**KIRKLEES METROPOLITAN COUNCIL
INVESTMENT & REGENERATION SERVICE**

Reference No: 2021/62/92162/W

Site Address: 43, Gramfield Road, Crosland Moor, Huddersfield,
HD4 5QB

Description: Erection of single and two storey rear extension and
side porch (modified proposal)

Rear Elevation 1.100

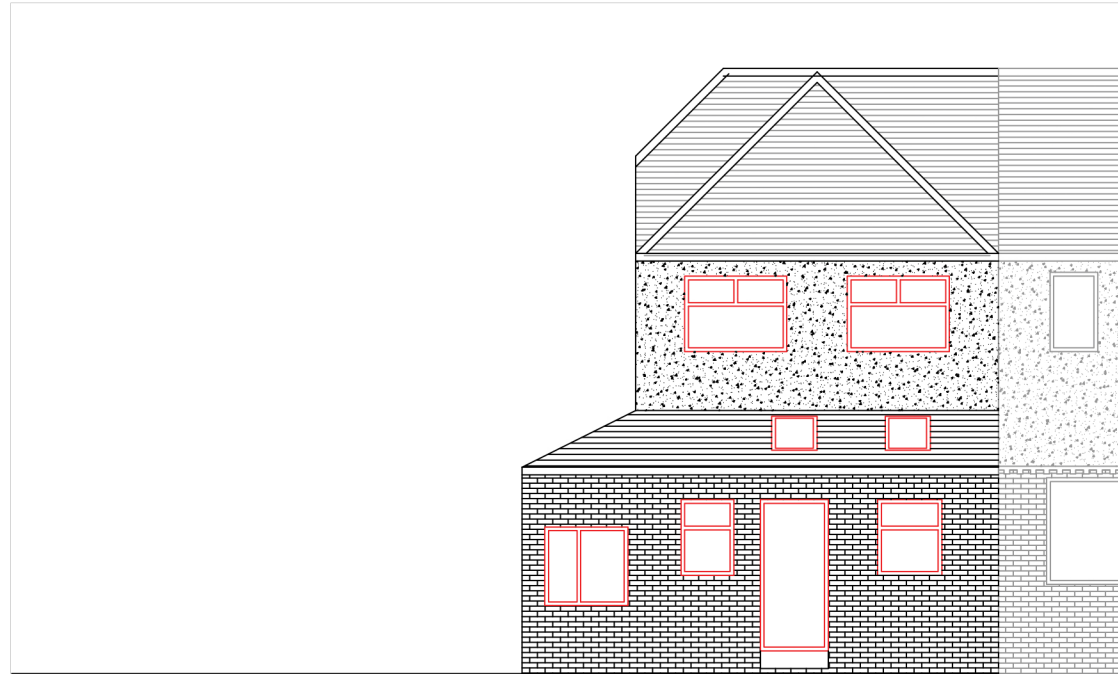
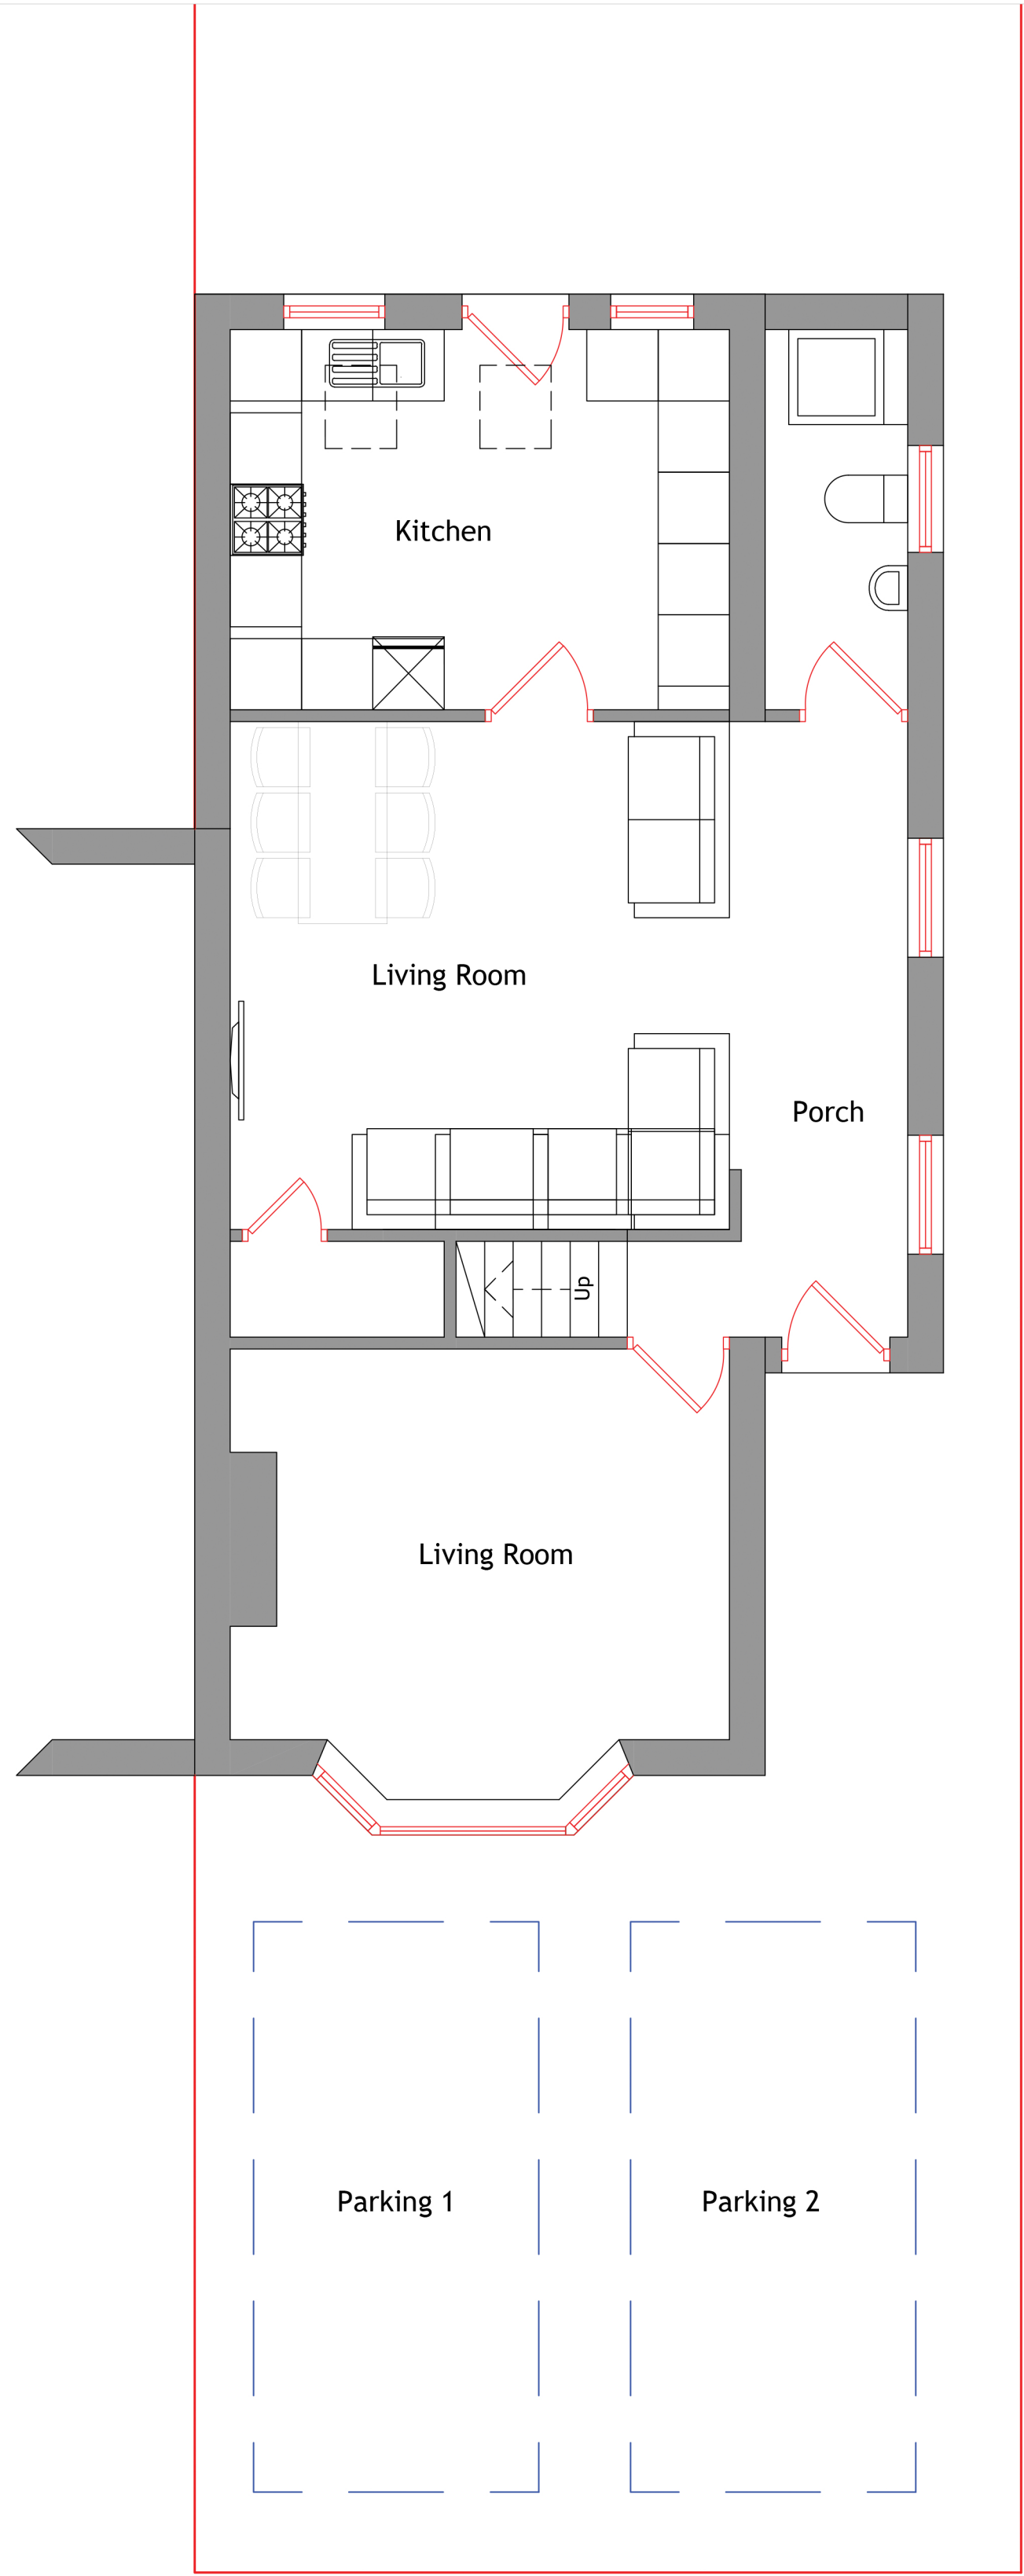
Officers entered into discussions with the agent regarding a discrepancy between the proposed elevations and floor plans. As such, the rear window to serve the downstairs bathroom has been removed and an amended plan was sought on the 12th July 2021.

Given that the amendment sought was to remove a window within the rear extension, officers did not consider it necessary to re-advertise the scheme.

Ground Floor Layout 1.50

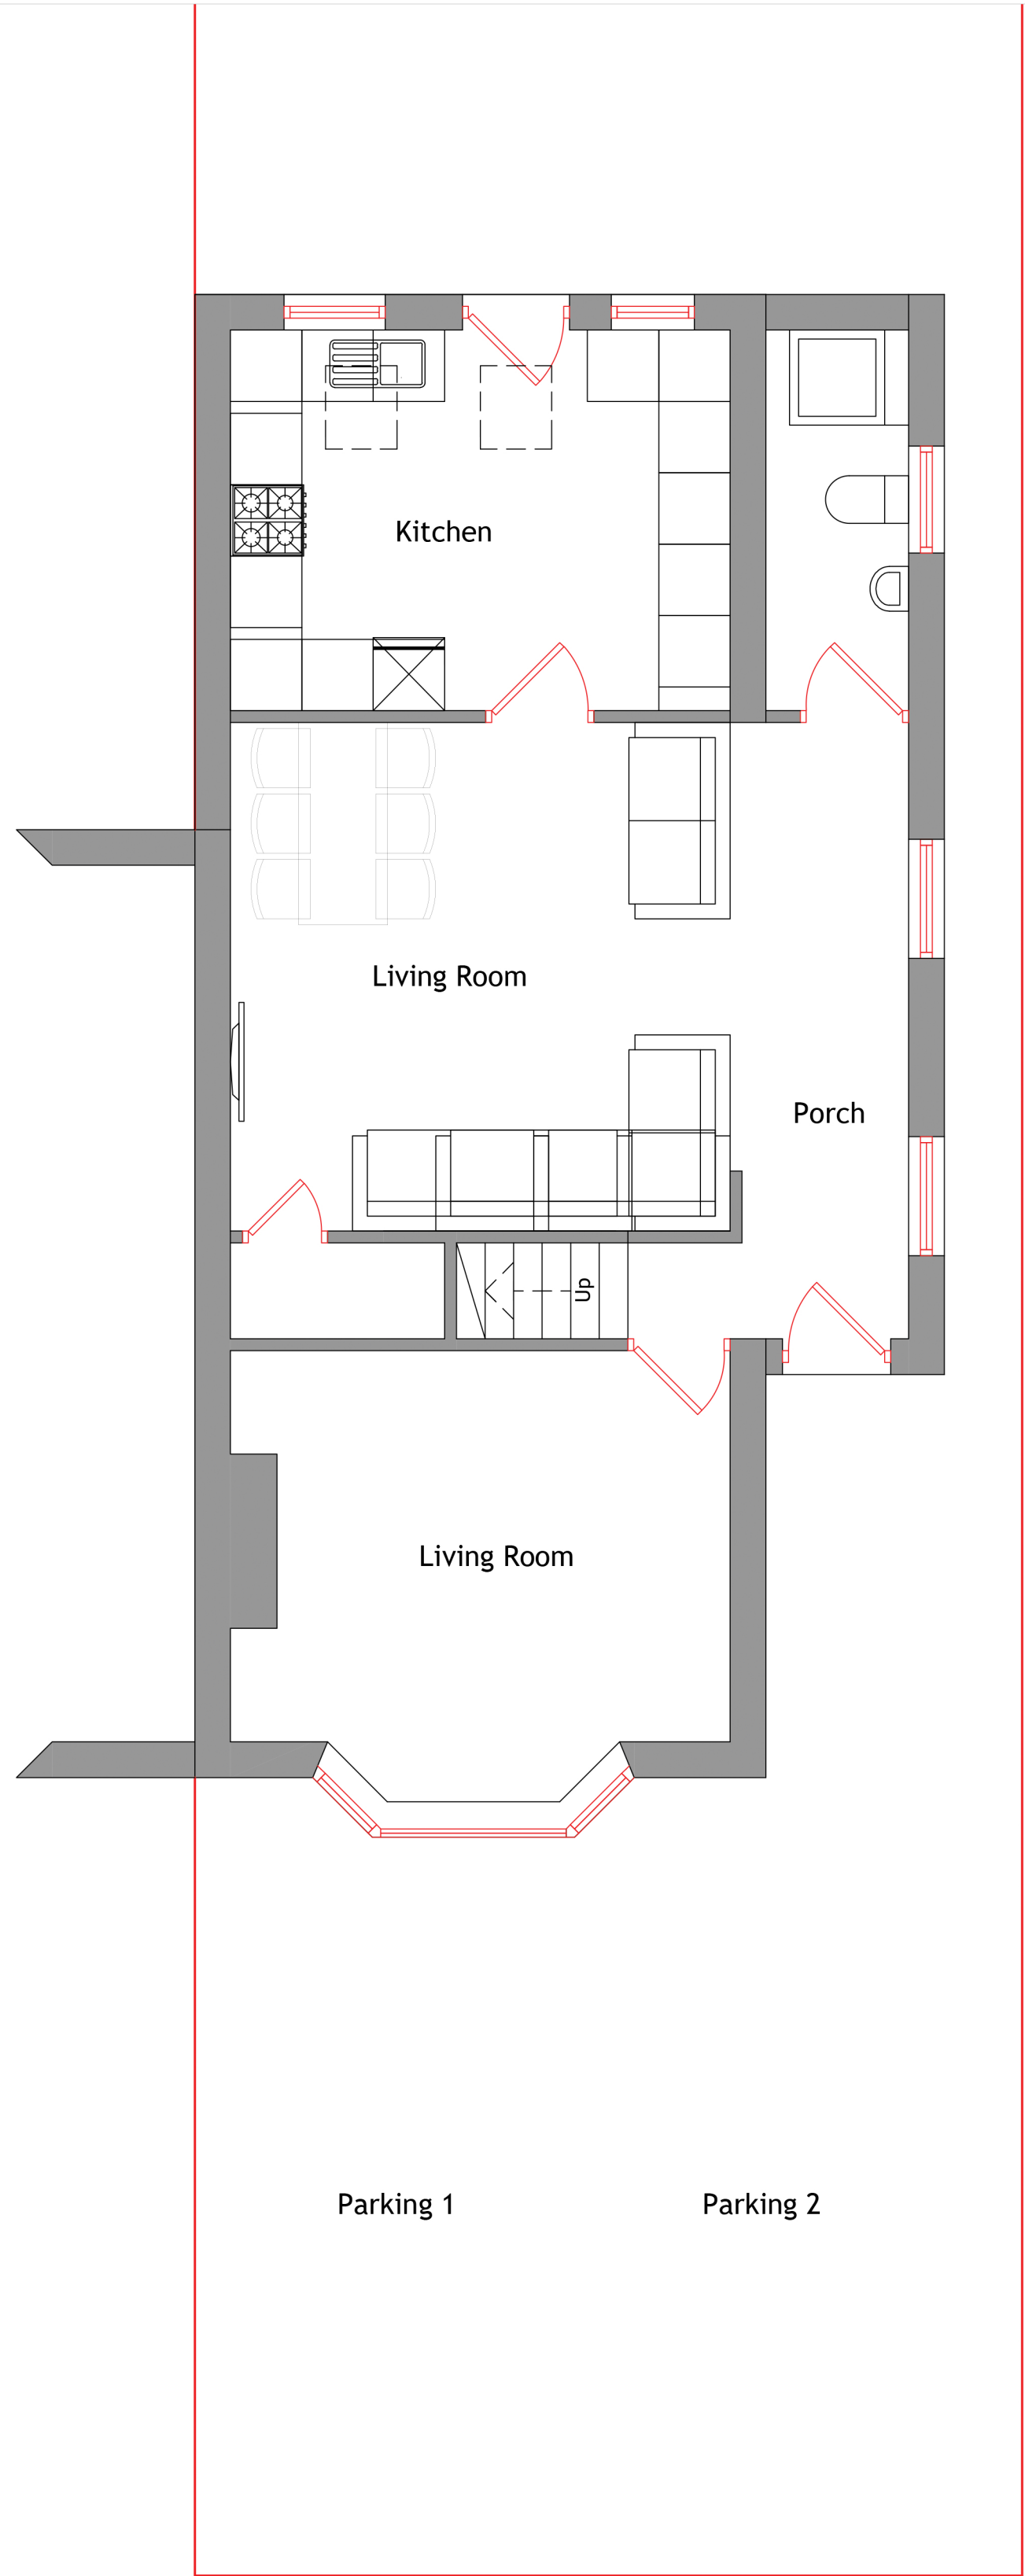
Given that the proposal has the potential to intensify the domestic use at the site, taking the property to a 3 bed, two on-site parking spaces have been demonstrated on the proposed floor plans. Each space would be at least 2.4m in width by 4.8m in depth. Therefore, the additional on-site parking is welcomed.

Alongside the above, a further condition would also be attached to the decision notice to ensure that the driveway is appropriately surfaced and drained in accordance with standard guidance to ensure that the additional hard surface does not result in an increase in surface water run-off and flood risk. This would accord with Policies LP28 and LP34 of the Kirklees Local Plan.
